MECKLENBURG COUNTY  
Park and Recreation Department

MEMORANDUM

**DATE:** December 16, 2020

**RE:** Rezoning Petition #2020-086 – Greystar - University City Blvd.

RZ-3.0

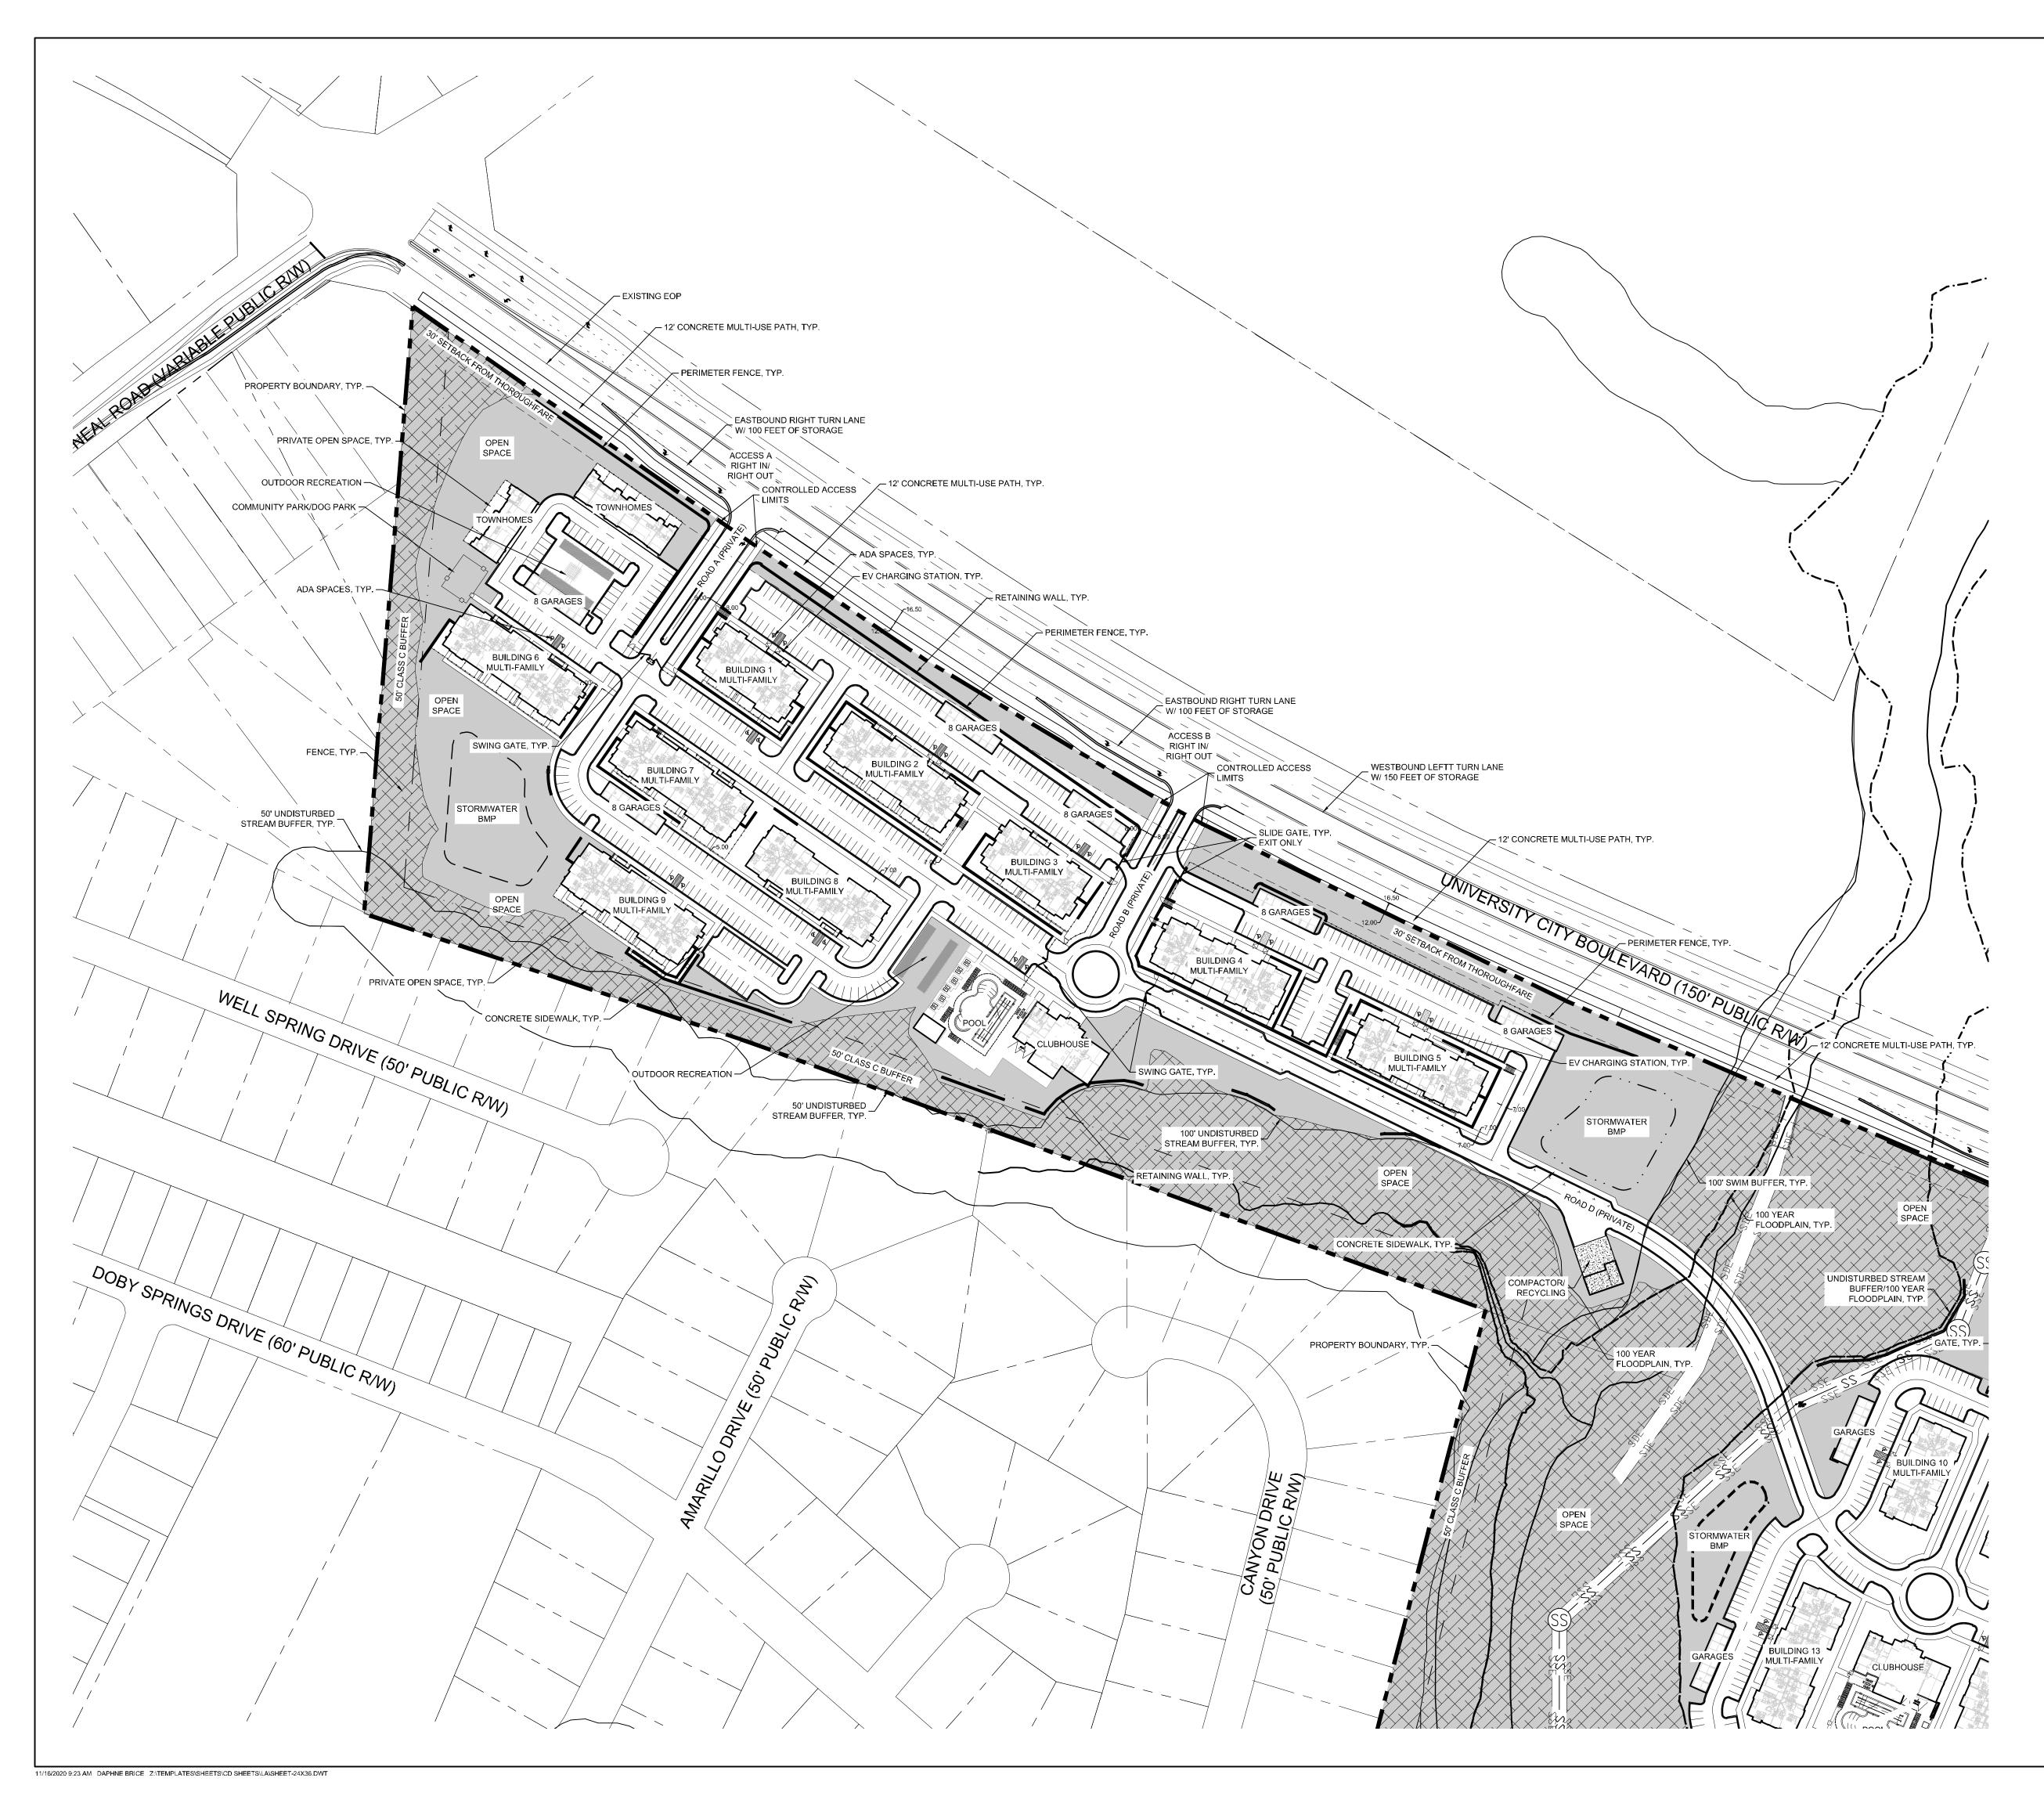
MCPR requests the petitioner dedicating and conveying or providing a greenway easement of the same area to Mecklenburg County - the entire 100 Year Floodplain minus any BMP infrastructure of Doby Creek. This parcel is on the MCPR Greenway Master Plan.
